Meeting Notes

Project: 1049 The Dice , Uxbridge

Workshop: Secured by Design review meeting

Date: 13.04.18 at 09.30am

drawing title
Proposed Parking Strategy
Basement and Ground Floor

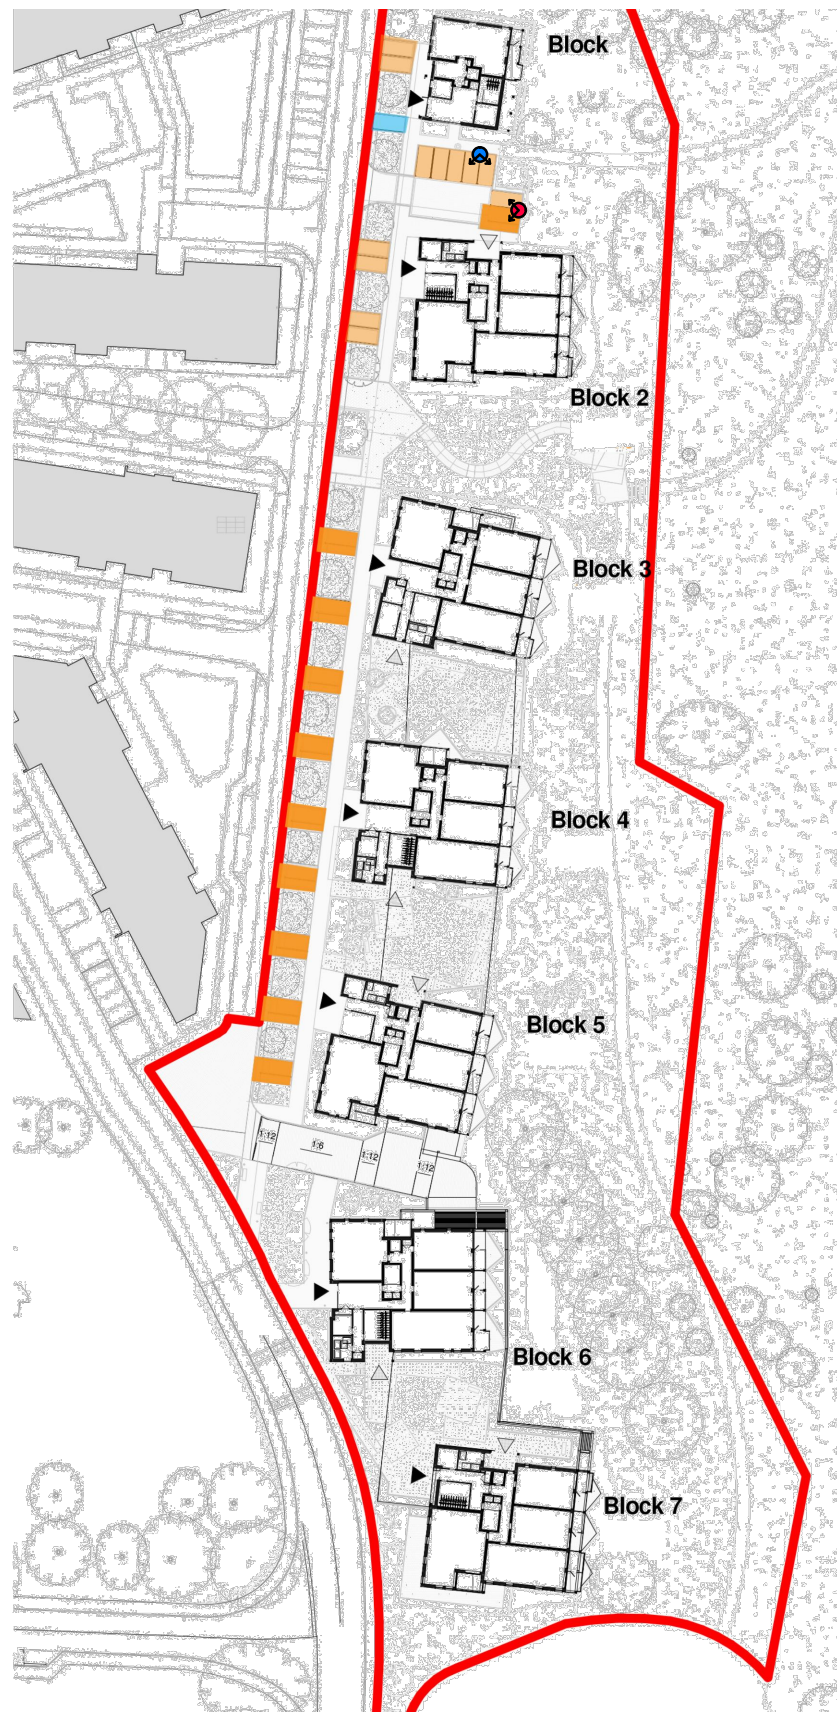
3.1	RP confirmed that gate to basement car park should be LPS 1175 SR1 security rated with self-shutting mechanism and fob-in / fob-out access control.	FBM

3.2	RP recommended that parking spaces are allocated to units and numbered without correlating numbers to flat numbers.	StMH
3.3	RP recommended that basement cycle stores should be discreet (no signage) with blockwork walls if possible and PAS 24 doors. Different blocks should require different fobs to access cycle stores, to restrict access.	FBM / DRH

drawing title
Proposed Refuse Strategy
Ground Floor

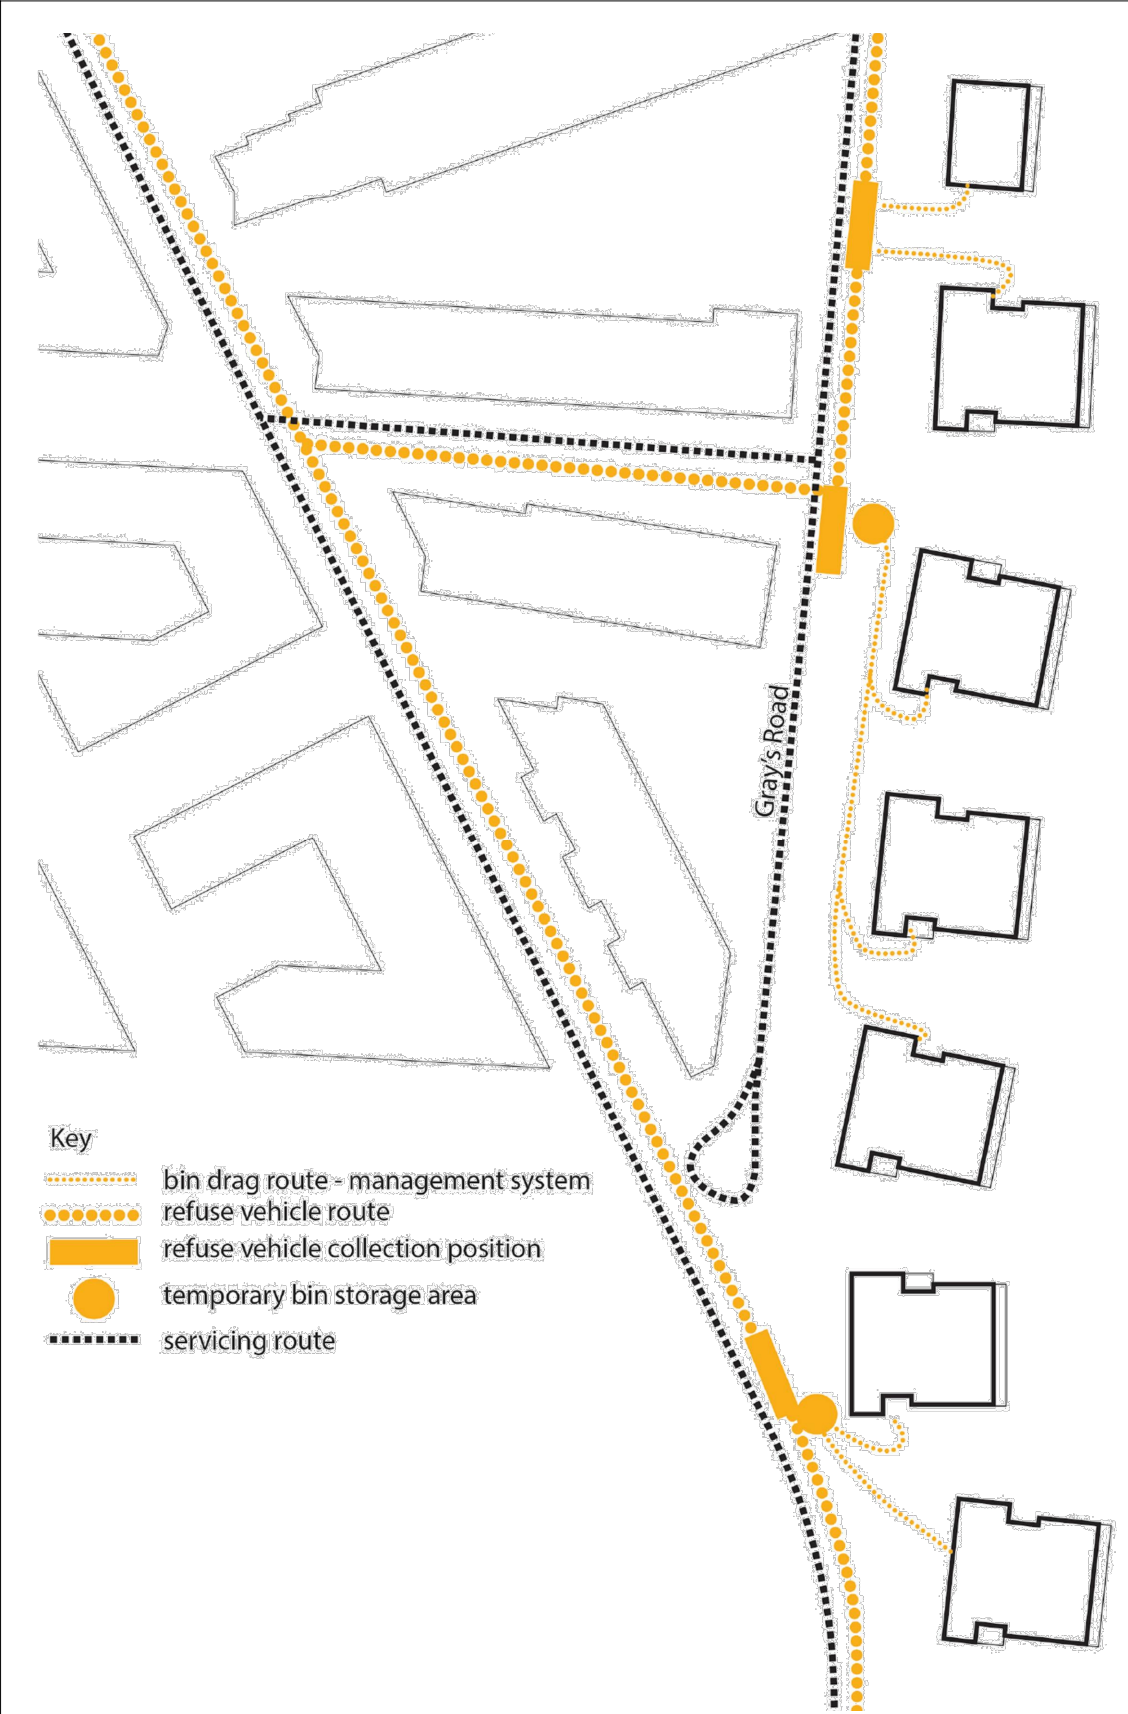
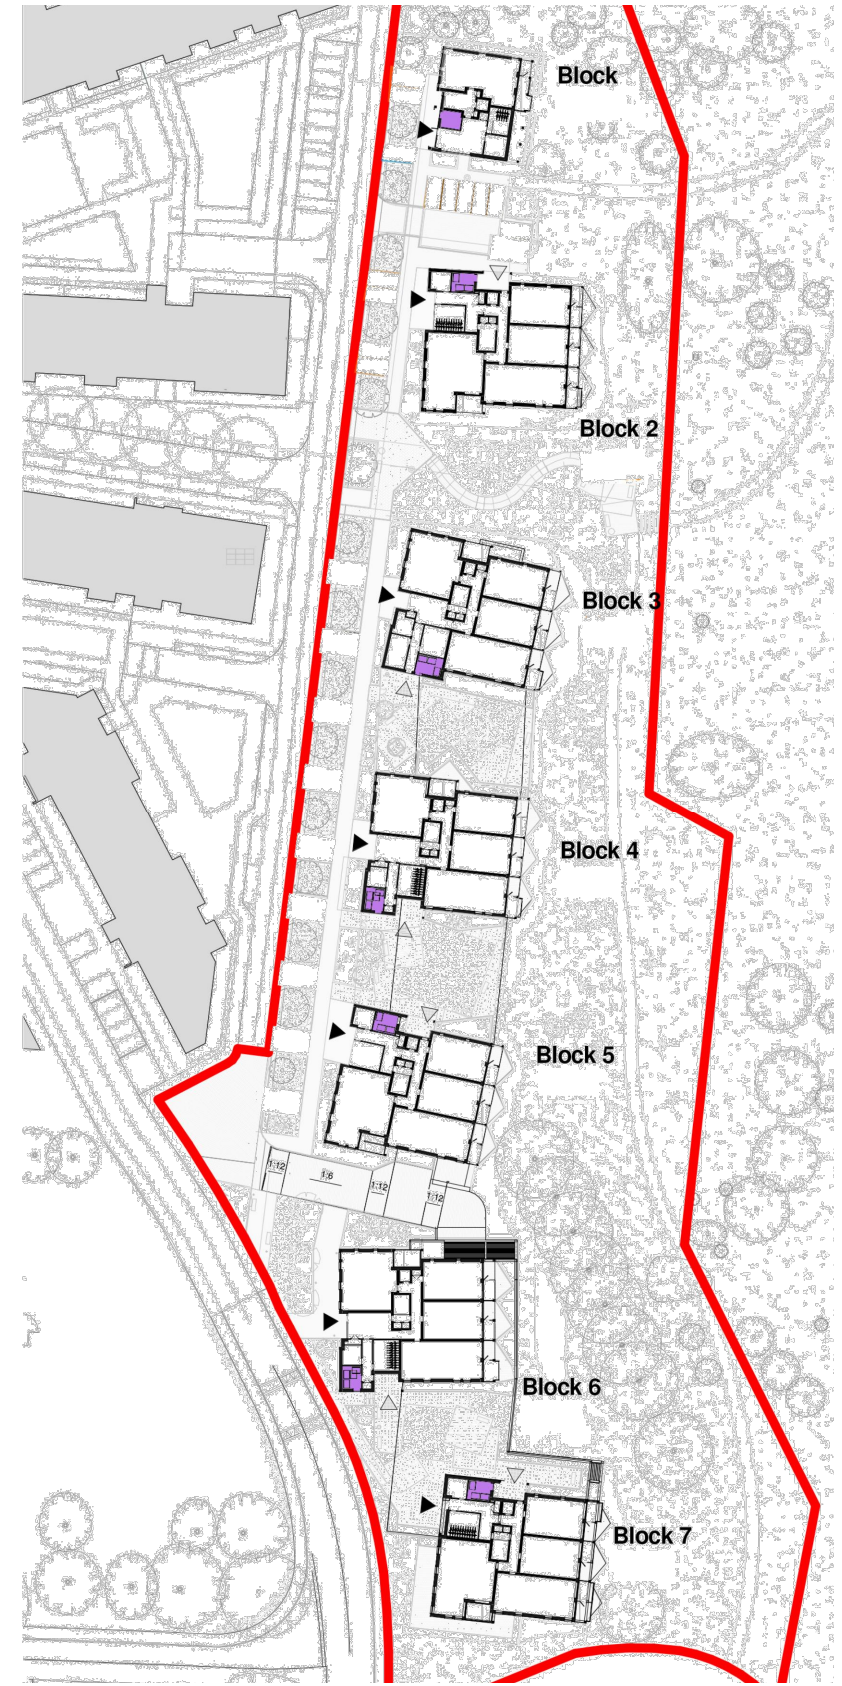
4.4	RP noted that bin store doors do not have to be security rated but it would be preferable. RP recommended specifying a single leaf door that allows for Euro-bins rather than double doors.	FBM
